# **OXFORDSHIRE COUNTY COUNCIL'S RESPONSE TO CONSULTATION ON THE FOLLOWING DEVELOPMENT PROPOSAL**

**Application no:** 22/03877/F

**Proposal:** Erection of three industrial buildings, replacement of former scout hut building and associated works

**Location:** Hatch End Old Poultry Farm, Steeple Aston Road, Middle Aston, OX25 5QL

REV.	I - 19.04.23 - Application boundary amended		
PROJECT	Hatch End Industrial Estate, Middle Aston		
TITLE	Site Plan, Proposed		
SCALE	1:750 @ A3	DATE	25.07.22
DWG. NO.	2203.PR.03	REV.	I

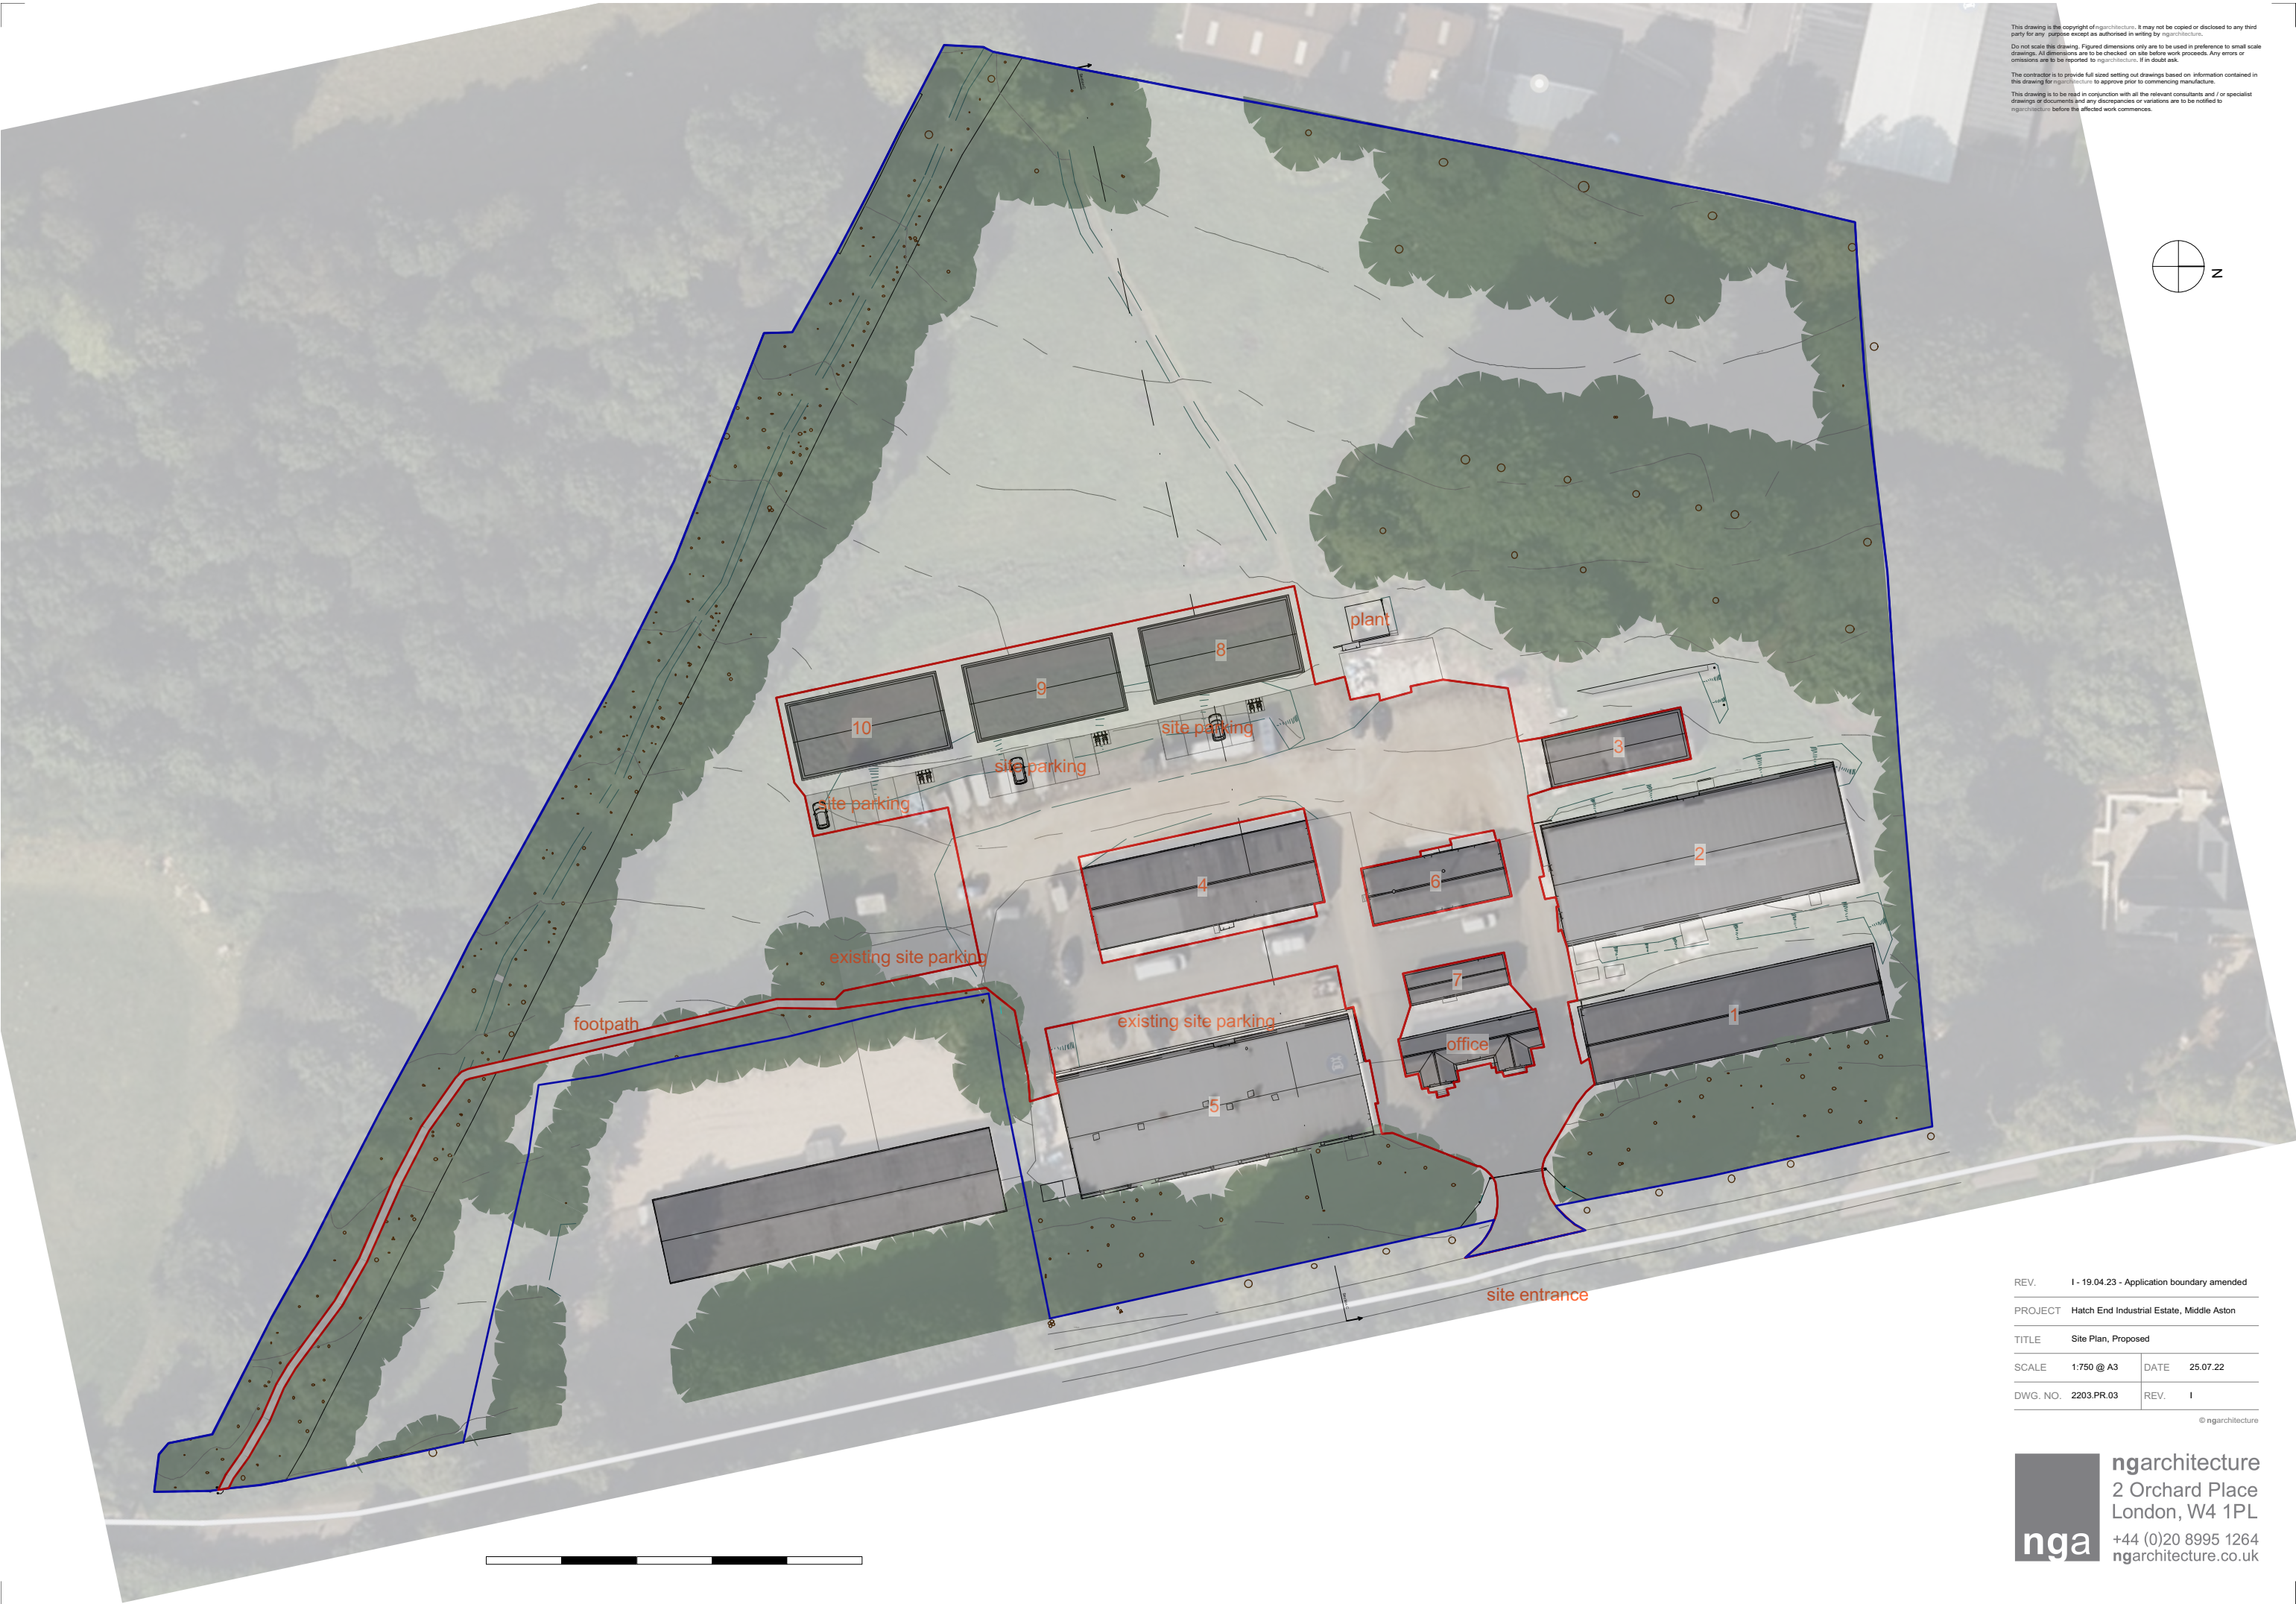
It is to be noted that with the current planning application no. 22/03877/F there has been no mention of a footpath connection within the transport statement or any drawings provided. A pedestrian footway connection is required between the site access and the closest footpath connection, 310 metres towards the Primary school, along the public highway. **Reason for objection.**

The proposed provision of 10 cycle parking spaces therefore meets the County's standards. However no cycle parking provisions are shown on the Site Plan. Details of the location, type and quantum of cycle parking spaces can be provided in discharge of a condition of planning permission.

The proposed provision of 24 car parking spaces represents an over provision which should be adjusted downwards to meet the County's standards. Electric Vehicle charging points will also need to be provided in accordance of Policy EVI 8 of the Oxfordshire Electric Vehicle Infrastructure Strategy. Details of a revised car parking layout can be provided in discharge of a condition of planning permission.

Prior to the first use or occupation of the development hereby permitted, covered cycle parking facilities shall be provided on the site in accordance with details which shall have first been submitted to and approved in writing by the Local Planning Authority. The covered cycle parking facilities so provided shall thereafter be permanently retained and maintained for the parking of cycles in connection with the development.

Notwithstanding the details submitted, no development shall commence until and unless a plan detailing the proposed parking provision for vehicles to be accommodated within the site, to include provision for electric vehicle charging, has been submitted to and approved in writing by the Local Planning Authority. The approved parking facilities shall be laid out and completed in accordance with the approved details before the first occupation of the buildings. The car parking spaces shall be retained for the parking of vehicles at all times thereafter.
